**Case Officer:** Gemma Magnuson

**Recommendation:** Application  
Permitted

**Proposal:** Variation of condition 2 (plans) of 17/02372/F – Alteration to openings

Scale:
1:5 @ A3
Number:
402_Rev.C

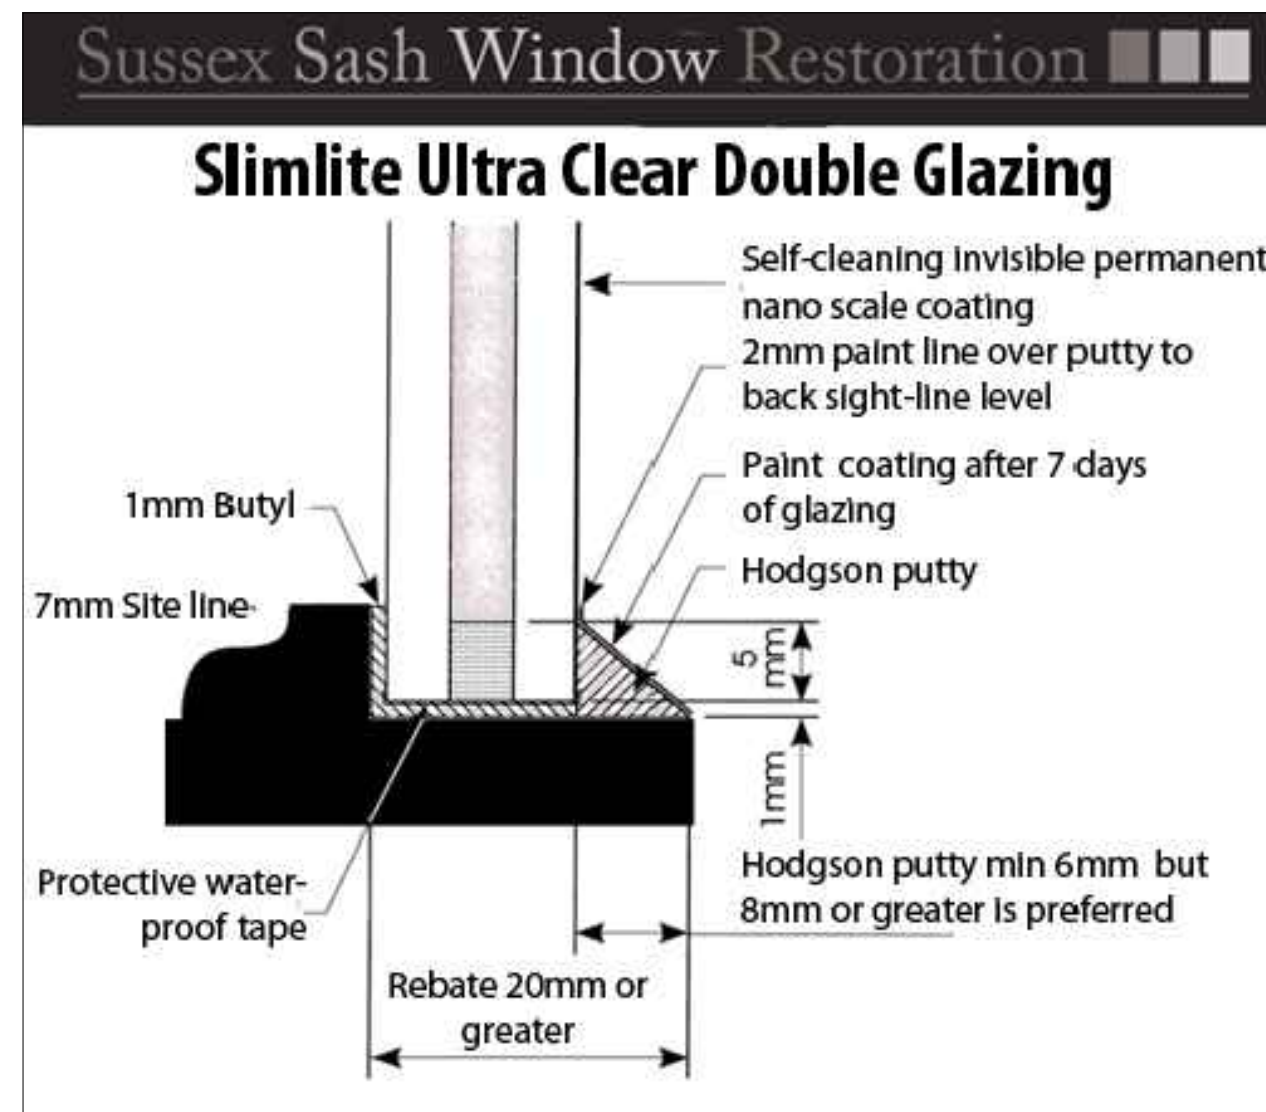
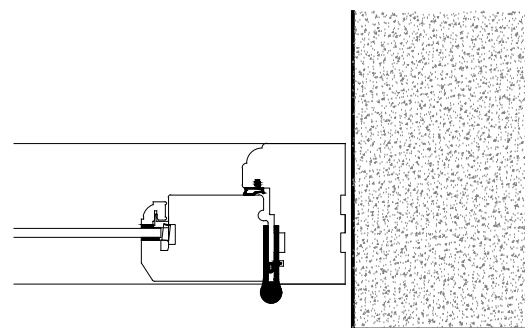
- 6.3. CDC Conservation – The general proposals are now considered acceptable. Further details are required of the proposed sections of the windows and doors. Slim lite double glazing is considered acceptable, but standard double glazing isn't. Rooflights should be flush with the slope of the roof and not situated on top of the rafters. The details can be submitted in advance of the determination of the application or can be attached as a condition. Amended plans were received on 15.11.2019 and the Conservation Officer verbally advised that these are acceptable on the same date.
